Your ref: TR050007  
My ref: DCO/TR050007/HinckleySRFI

**TR050007 Hinckley SRFI – Warwickshire County Council (20040686 )  
Comments on Documents Requested to be Submitted by Deadline 1**

Doc Ref 18.1.3 Rev 01 Post hearing submission ISH1 and CAH1 [Appendix C Applicant's Updated Responses to the ExA's Initial Observations on Drafting of dDCO]

Figure 2: Revised Furnessing Methodology

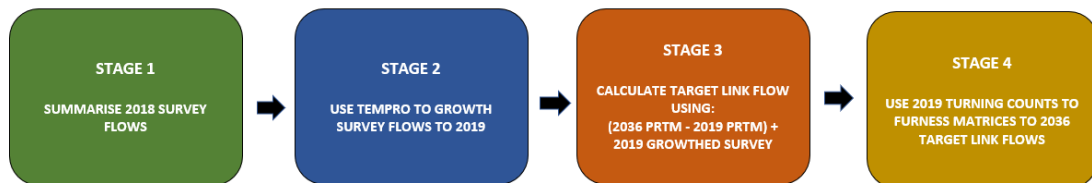
Modelling (iv) Furnessing – some outstanding queries remain over the furnessing methodology and treatment of 'zero' or 'close to zero' cells; and at the Cross-in-Hands junction (junction 27 in Transport Assessment) there are differences between the modelled ARCADY capacity performance results and the Paramics results and this is potentially due to a difference in turning flow data (see below).
